From: Amanda Scholes on behalf of Planning.Responses
Sent: 27 July 2017 08:30
To: Planning Scanning
Subject: FW: Planning Consultation on: A/99/17/OUT

From: Sue Howell
Sent: 26 July 2017 16:41
To: Planning.Responses
Cc: David Innes
Subject: RE: Planning Consultation on: A/99/17/OUT

Comments from Greenspace

Description of Works: Outline application with some matters reserved (Access only) for development up to 175No. residential dwellings, public open space, play areas with associated infrastructure including roads, drainage & landscaping. This application affects the character & appearance of Angmering Conservation Area & the setting of Listed Buildings. This application is a Departure from the Development Plan

Tree Protection Plan

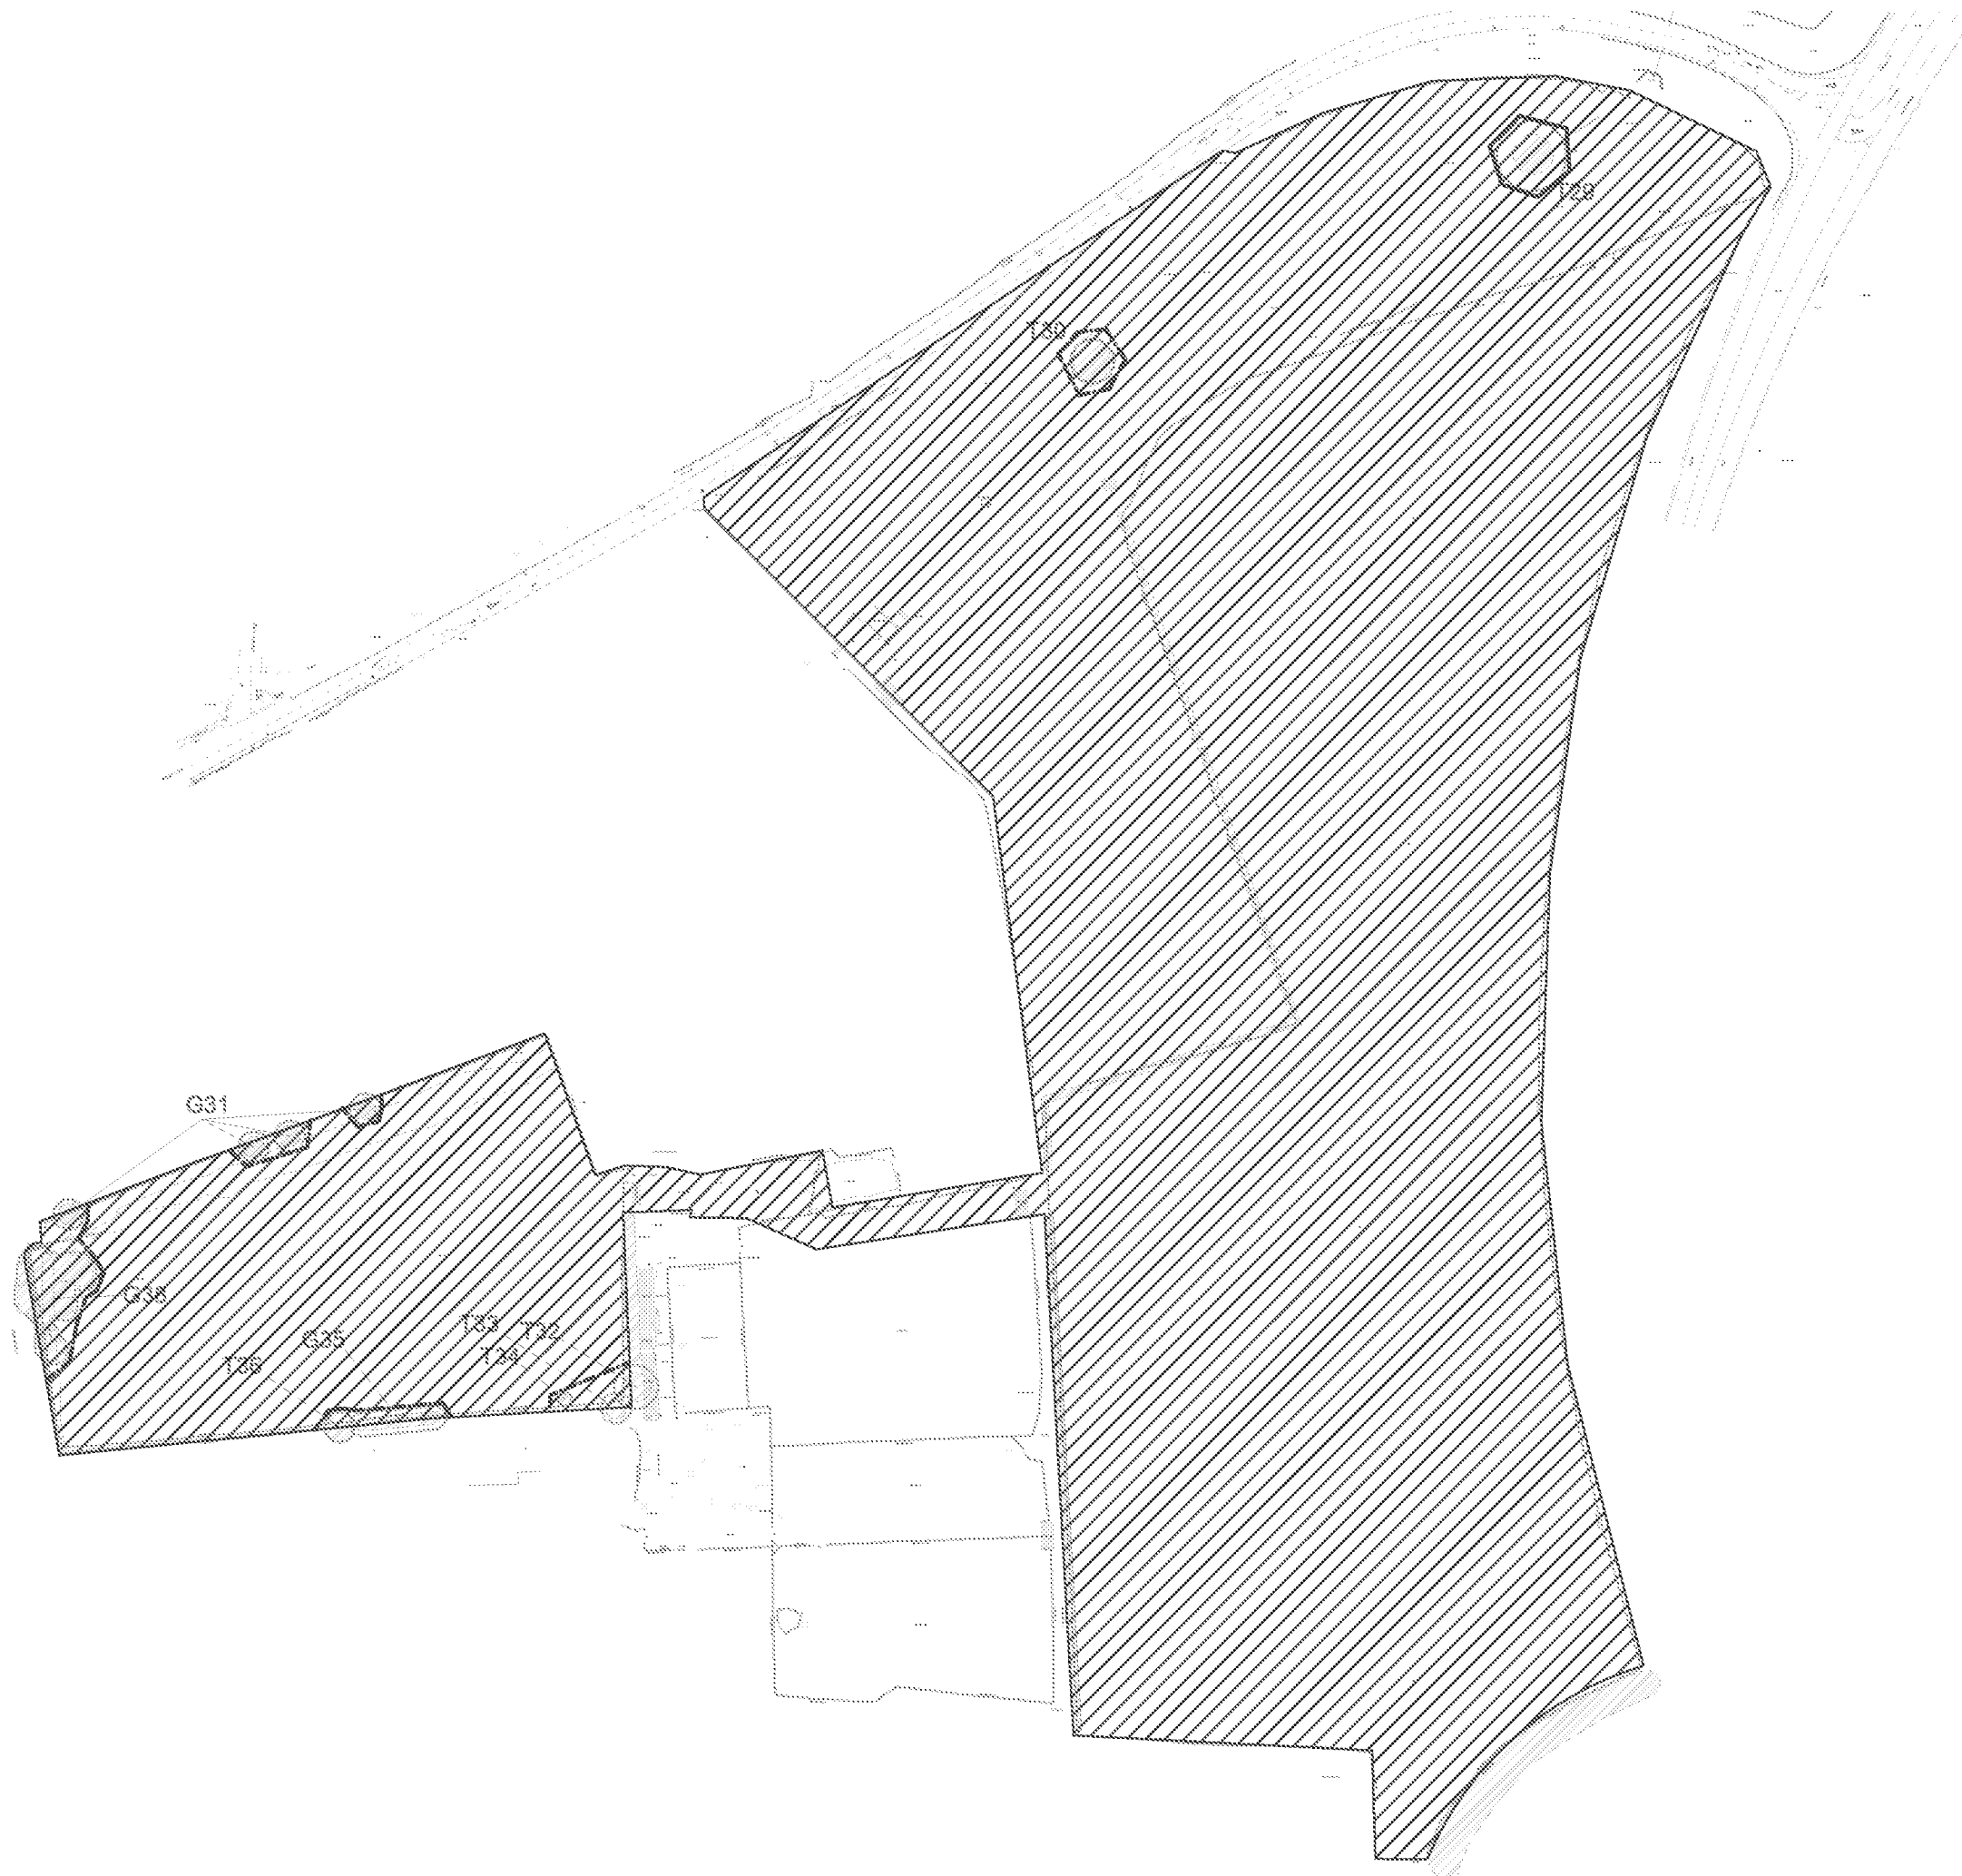
Landscape – Existing trees or vegetation that fall within the proposed or periphery of the development, may provide significant aesthetic impact to the location. Any trees in particular along the boundaries, which adjoin neighbouring properties could provide potential valuable screening and should be protected and retained. Any considered tree works within the site should be agreed with Arun District Councils Tree Officer. Further information concerning the existing hedges across

the site and proposed TPO for worthy trees will need to be provided. A tree condition survey of the application site to be provided to highlight the importance of retaining particular trees along with the condition of existing hedgerows locally and their contribution to the landscape should be included. Root protection Areas (RPA) for any retained trees to be concluded and should apply to trees on the periphery where roots extend into the development site. Before construction, a tree protection scheme must be in place for these trees. This would be required for both construction and heavy vehicle movements for deliveries. This should be in accordance with BS 5837:2012 'Trees in relation to construction'

Plan 2 – Green Infrastructure Space Plan

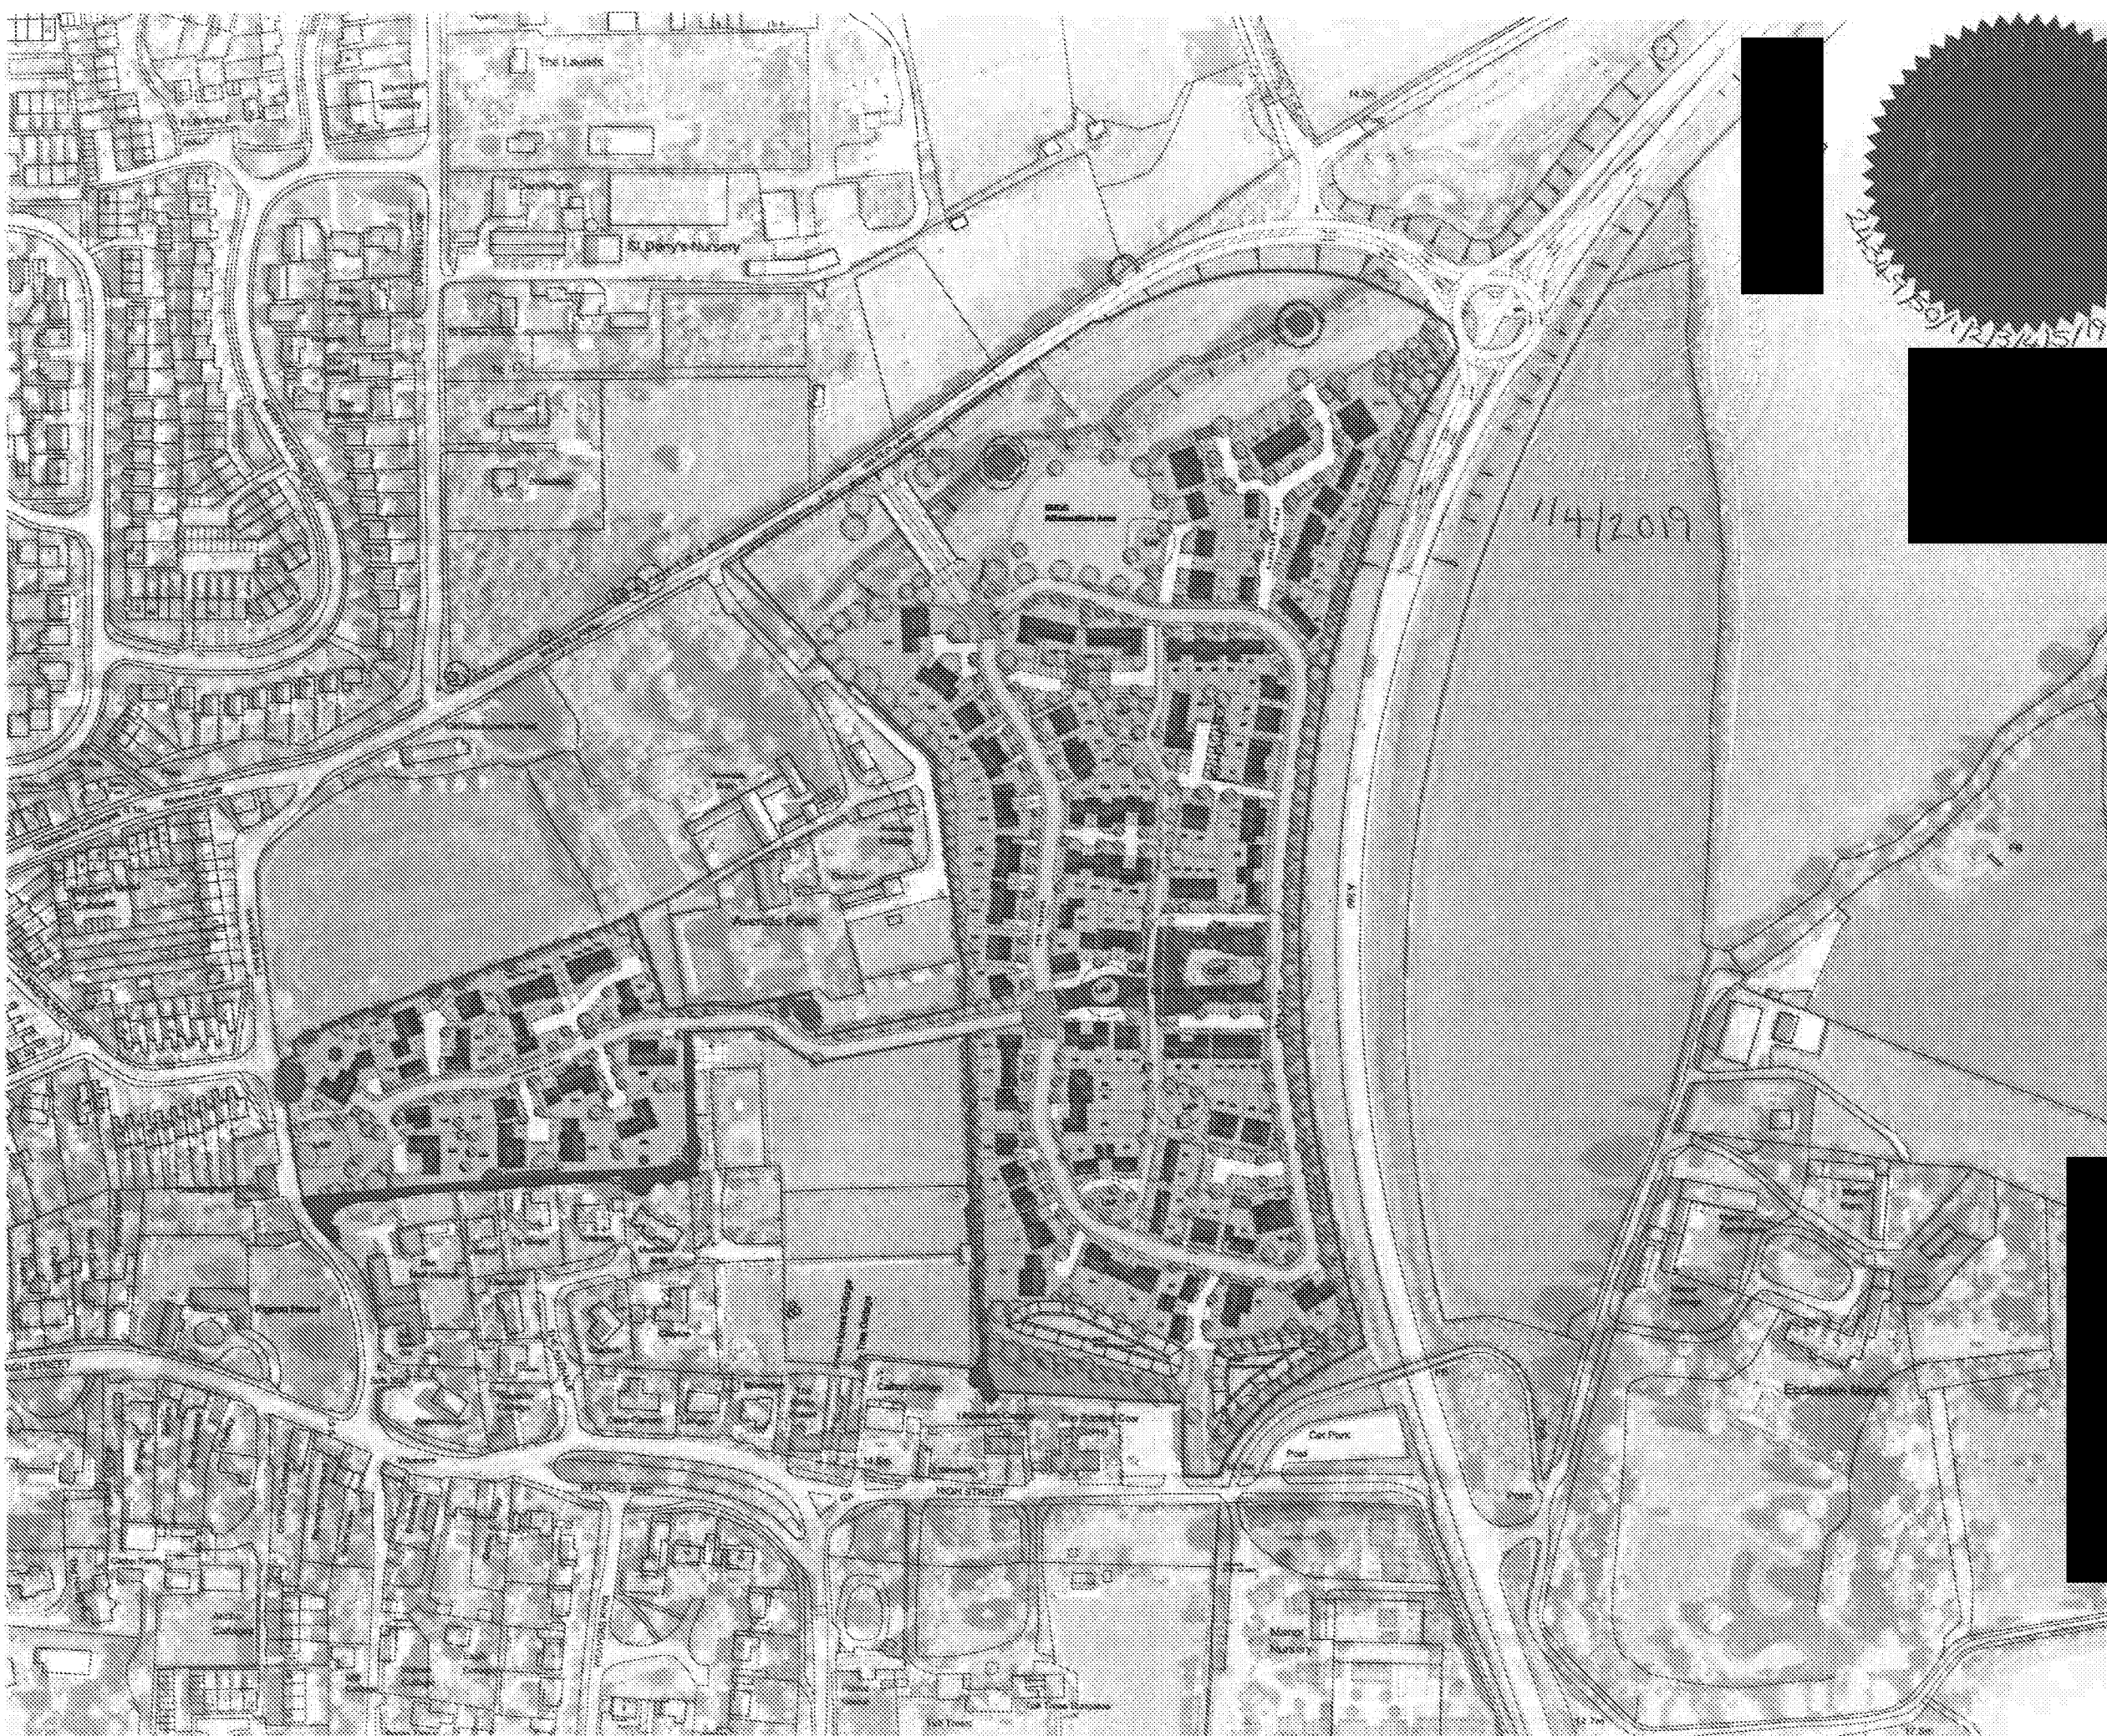
The indicative layout shows a fragmented site into two clear zones, consideration of both of these areas in relation to provision must be made. The indicated larger areas of open space appear to be very much to the north and south of the proposed development and somewhat divorced from the main residential areas. Whilst areas of open space are shown as buffer areas alongside the relief road they are not necessarily integrated within the development, the result being these areas are less accessible to residents.

A high proportion of the open space proposed is situated too far away from the residential development. The result has left the proposed development area with very limited open space within the proposed housing zones. Consideration should be made to the siting of open space and buffer areas more centrally within the proposals which would in turn provide a softening and green link across the development.
